REQUEST

Current Zoning: B-1(CD) (Neighborhood Business, Conditional), O-2(CD) (Office, Conditional)
Proposed Zoning: B-1(CD)SPA (Neighborhood Business, Conditional, Site Plan Amendment), O-2(CD) SPA (Office, Conditional, Site Plan Amendment)

The petition proposes a site plan amendment to petition 2014-069 to increase entitlements for medical office and health institution uses.

Novant Health Inc

RZ-2: Schematic Site Plan

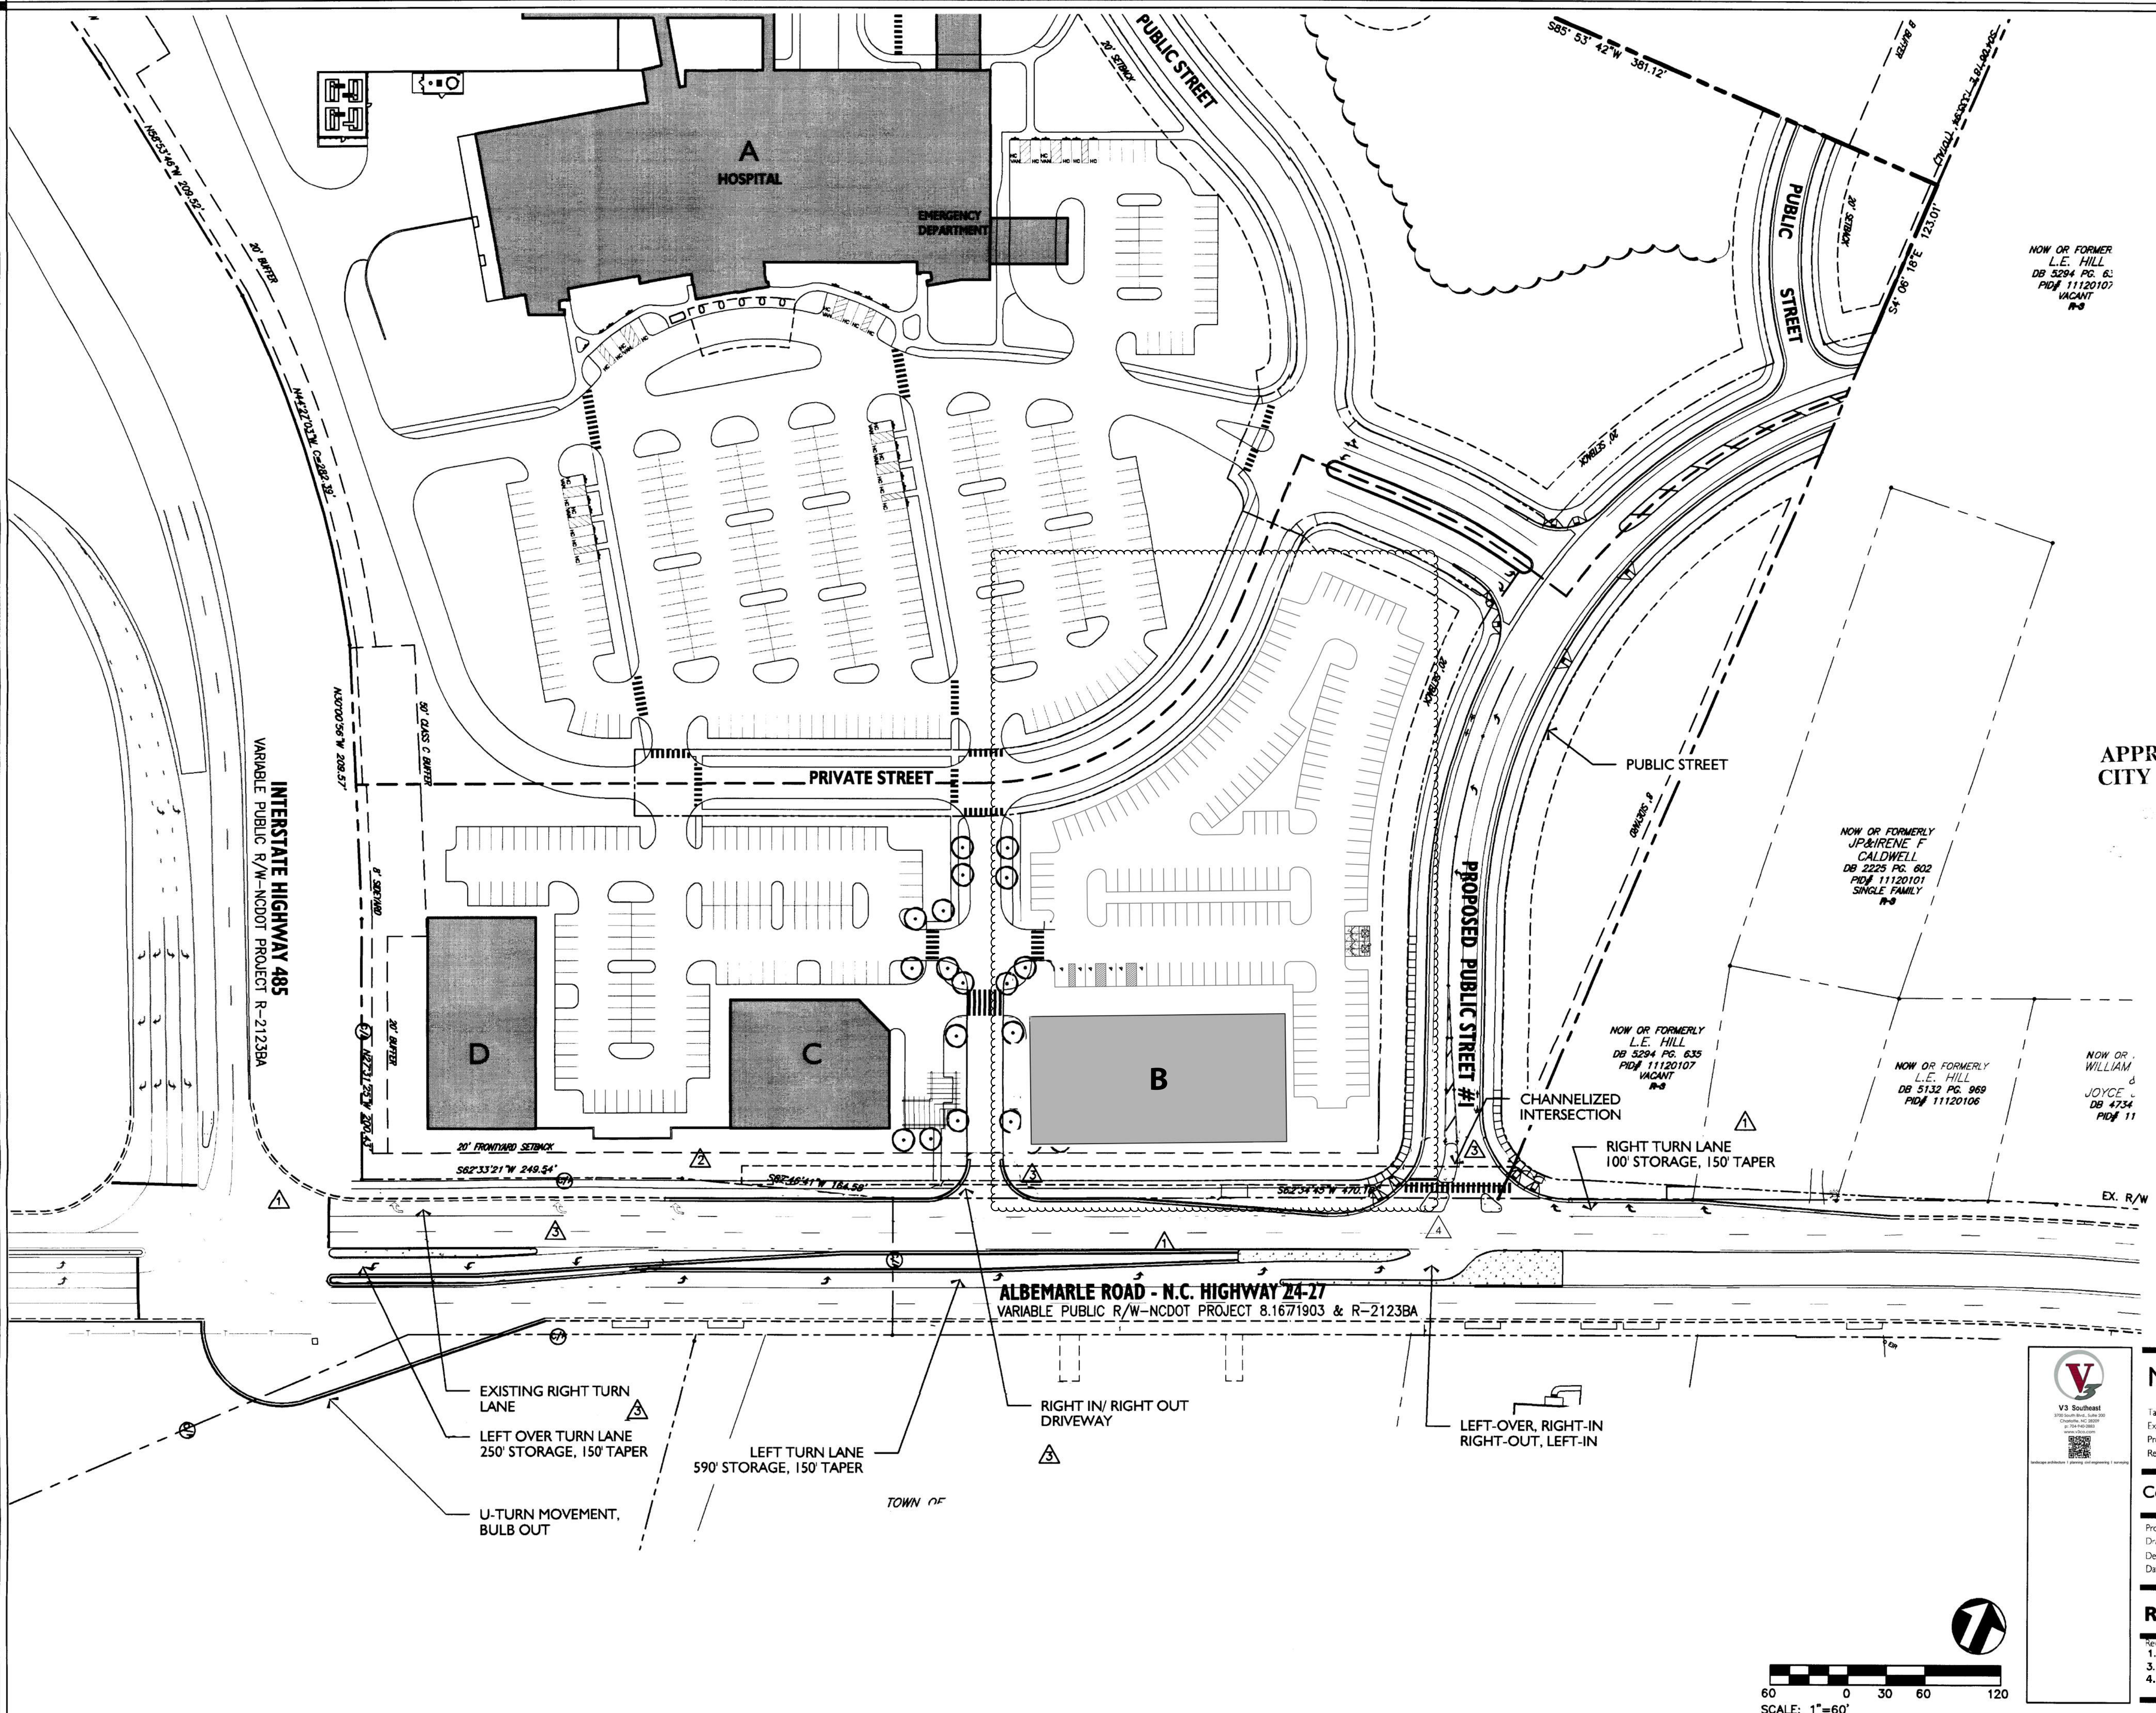
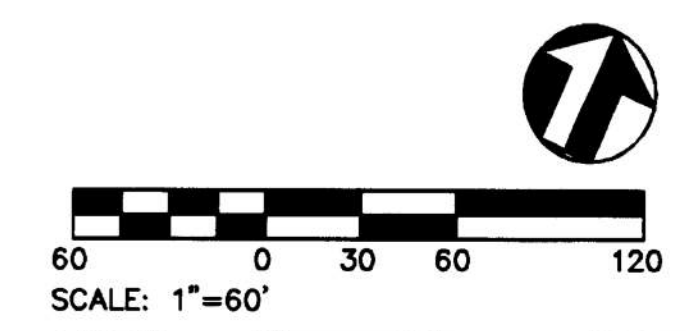
1. Clarify whether the Site Plan Amendment applies only to the B-1(CD) portion or to both the B-1(CD) and O-2(CD) portions, and update the rezoning request listing accordingly.

2. Add a Site Plan Amendment data table to summarize entitlement changes from the existing vs proposed plans. Confer with planning staff for templates.
